Subject: Covington Office Building at Academy Village Fil No 3 (PPR-18-021) review 1

EL PASO COUNTY PLANNING AND COMMUNITY DEVELOPMENT DEPARTMENT

SITE DEVELOPMENT PLAN

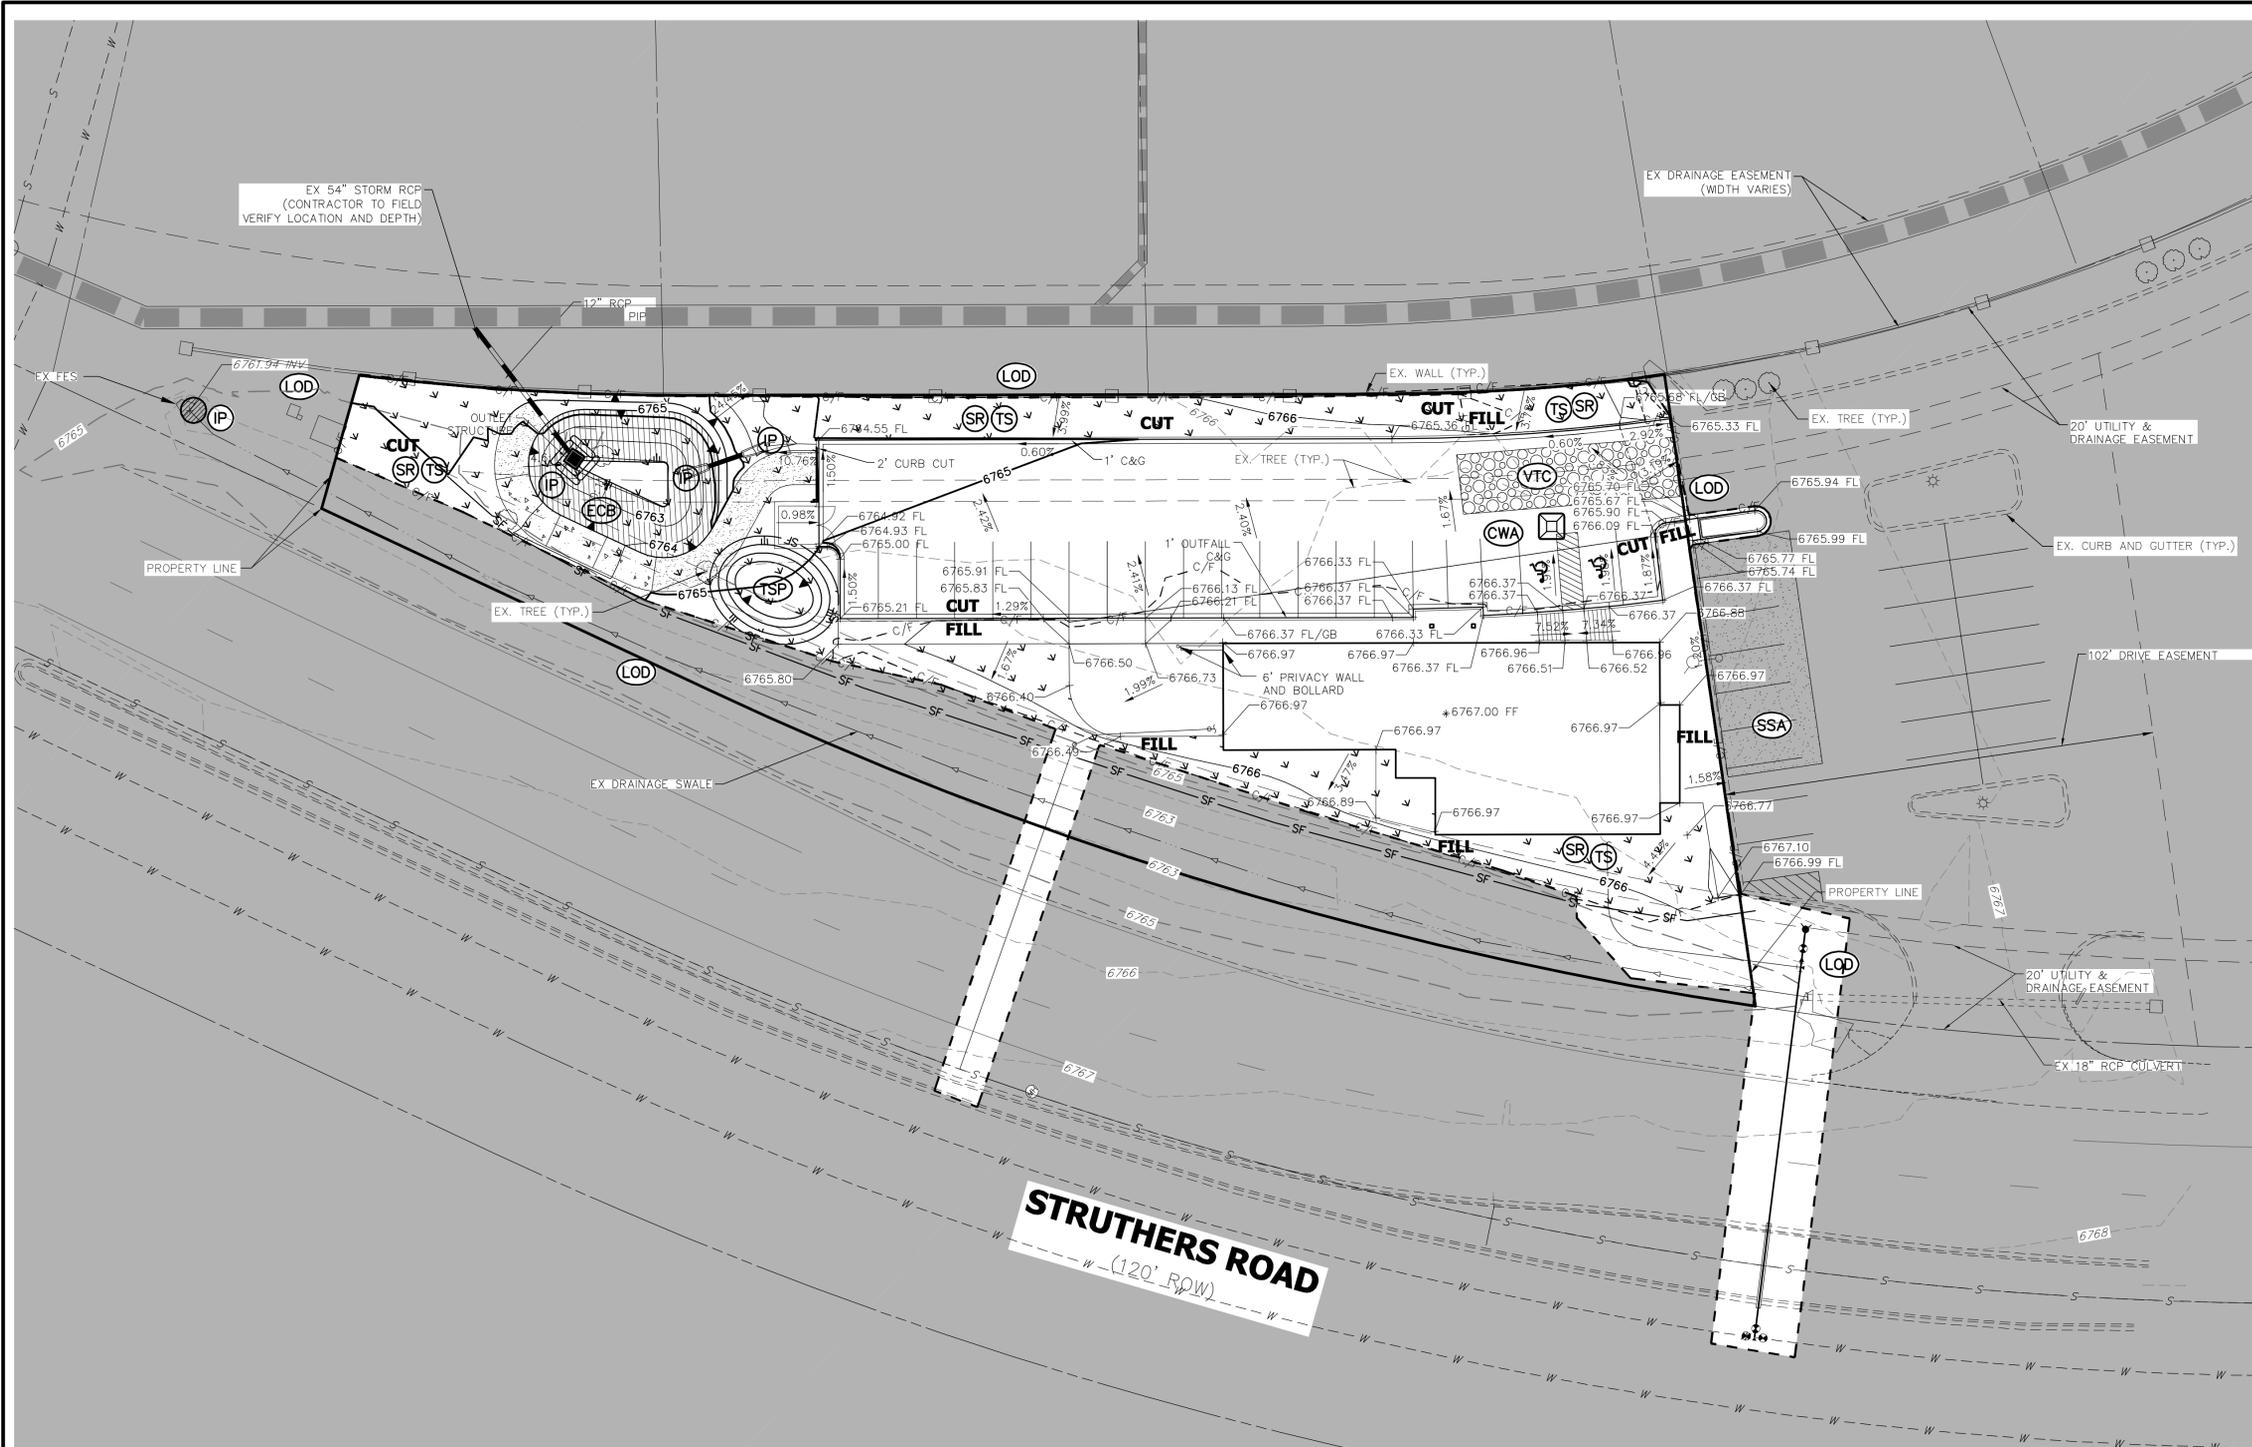
1. The legal description provided is for the driveway easement. Provide a legal description for the lot (Lot 2, Academy Village Filing No. 3) ... **correct legal description provided - DVH**
2. The replat (VR-17-012) submittal items pending approval and recordation include:
 - a. Plat document
 - b. Subdivision Improvements Agreement (SIA)
 - c. PDB/BMP Maintenance Agreement and Easement, including O&M Manual
 - d. Financial Assurance Estimate (FAE). This is only needed with the VR project unless there will be a transfer of responsibility after public improvements are completed ... **replat recorded - DVH**
3. The following items are being reviewed with the replat; comments provided below apply to that project:
 - a. Drainage Letter Report
 - b. Grading and Erosion Control Plan

PLANTING PLAN

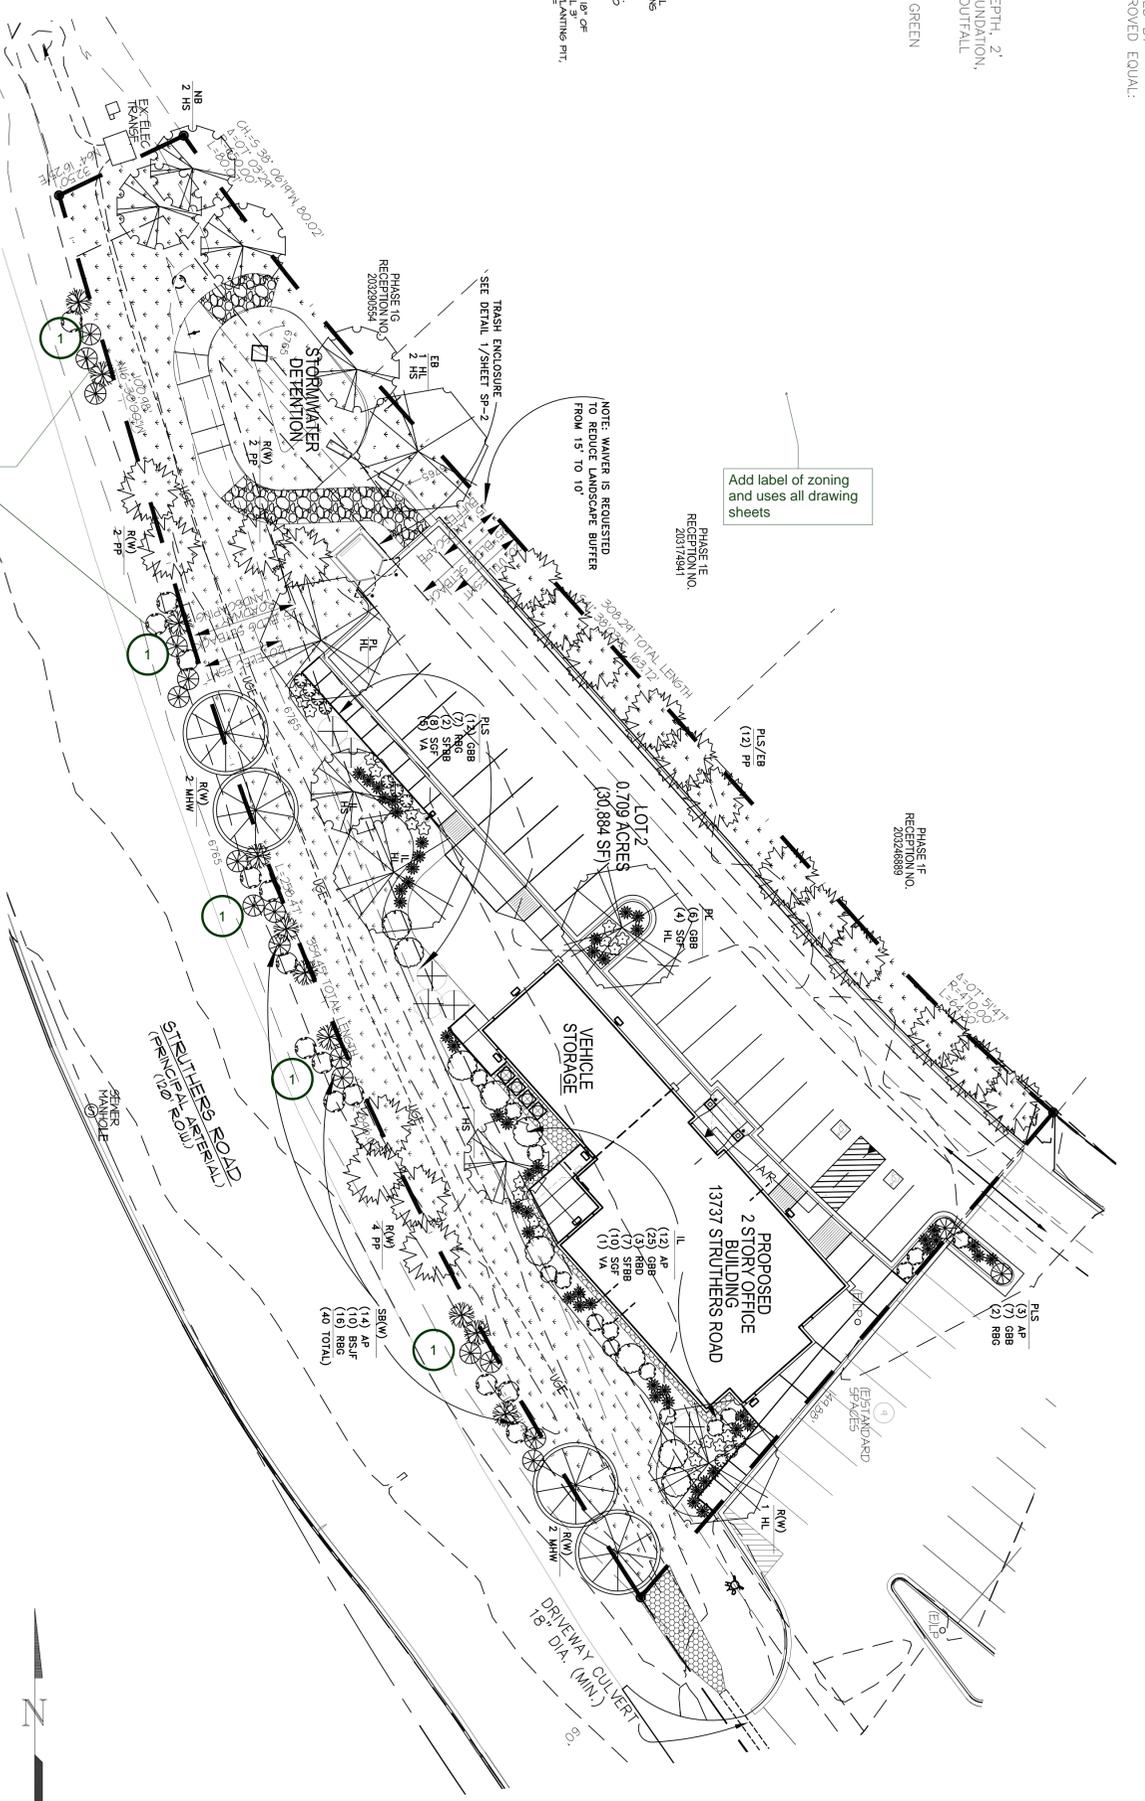
MVEA requests no trees or shrubs be planted, or placing of sound barrier walls/fences within ten (10) feet of any existing or newly constructed electrical facilities. If additional utility easements are needed MVEA will work with the developer in order to serve this commercial parcel. **EXISTING TRANSFORMERS TO NORTH OF SITE: TREES PLACED OUTSIDE OF REQUESTED 10' CLEARANCE. 20' EASEMENT FOR UGE ALONG STRUTHERS ROAD: TO MEET COUNTY LANDSCAPE REQUIREMENTS, (8) SMALL TREES PLACED 2' INSIDE OF PROPERTY/EASEMENT LINE. ALL OTHER PROPOSED PLANT MATERIAL PLACED INTERNALLY TO THE EASEMENT, OR JUST OUTSIDE THE PROPERTY LINE, IN R.O.W. PER AGREEMENT WITH COUNTY ENGINEERING - CA.**
